Department for  
Energy Security  
& Net Zero

Our Ref: EN010079

**Norfolk Vanguard Offshore Wind Farm Order 2022 – Proposed Non-Material Change Application 2023**

**POINTS OF CLARIFICATION**

Title:
Landfall location

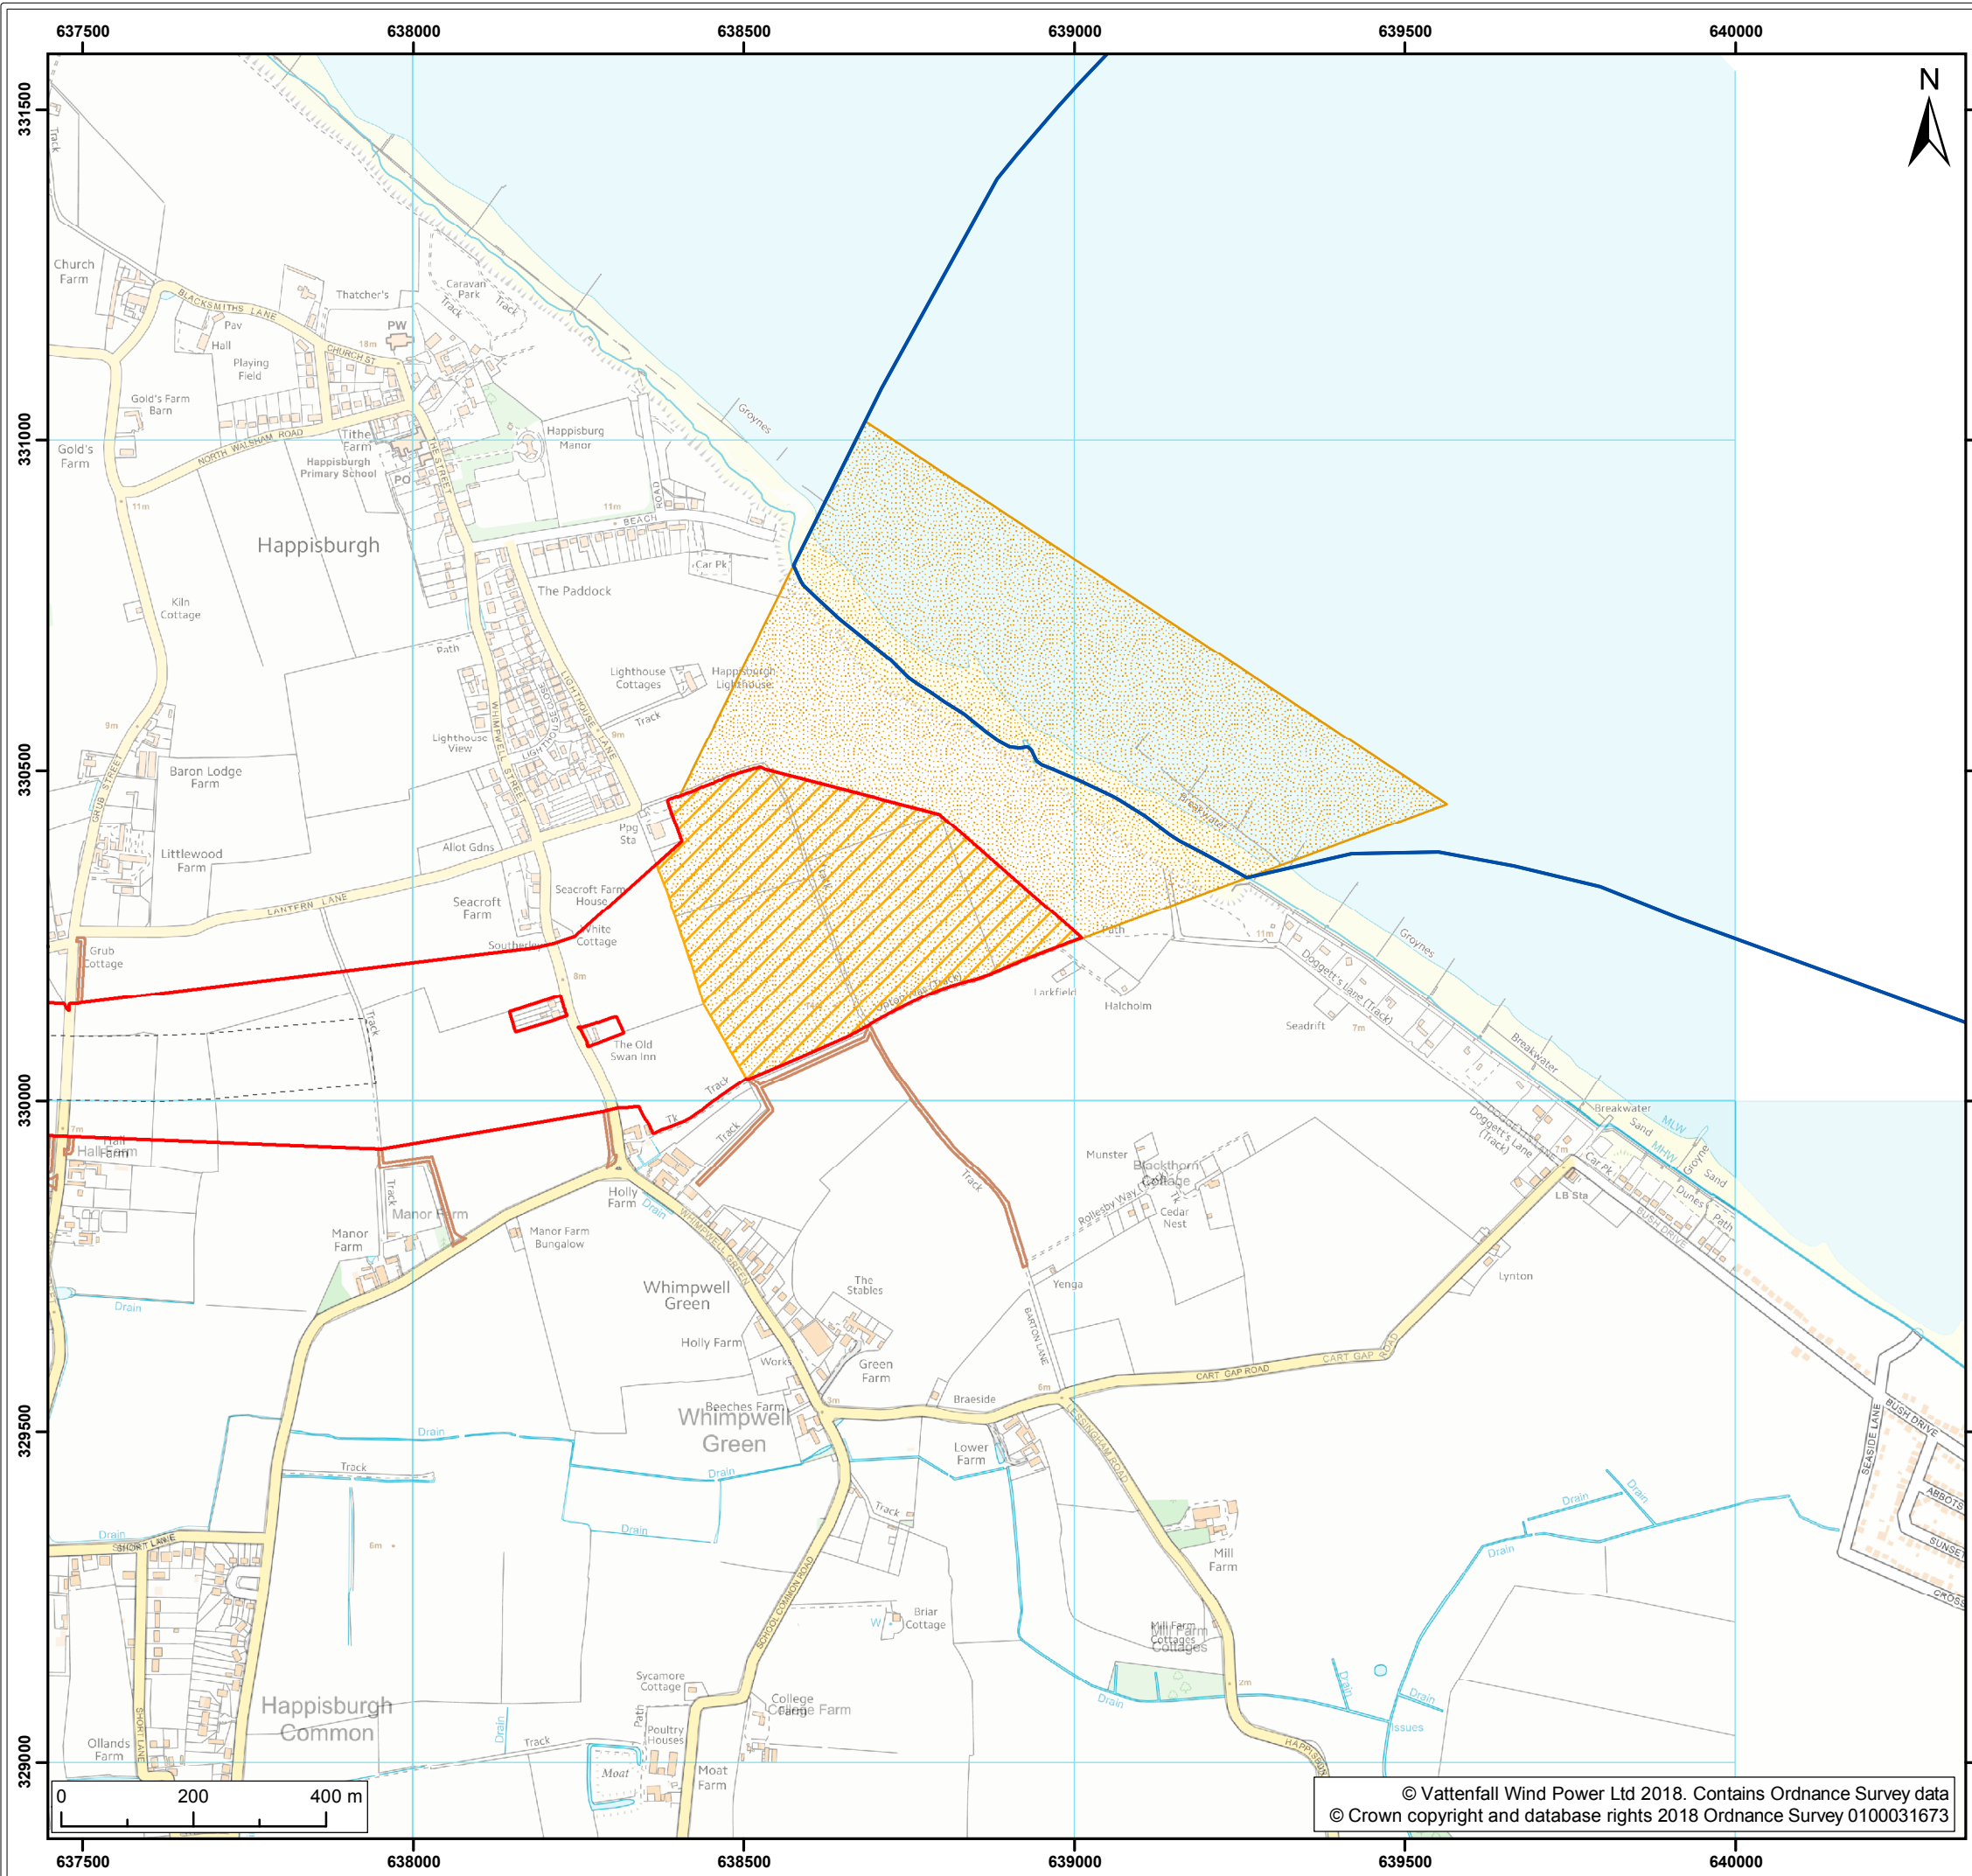
8. The Secretary of State notes that Figure 2 of the 2023 Application (Supporting Statement) appears to show physical cross-over between the landfall compounds of Vanguard with those of Boreas, which are shown in Figure 4.7 of the Boreas ES<sup>2</sup>. The **Applicant** should provide a plan showing the layout at landfall which combines all details for both Vanguard and Boreas.
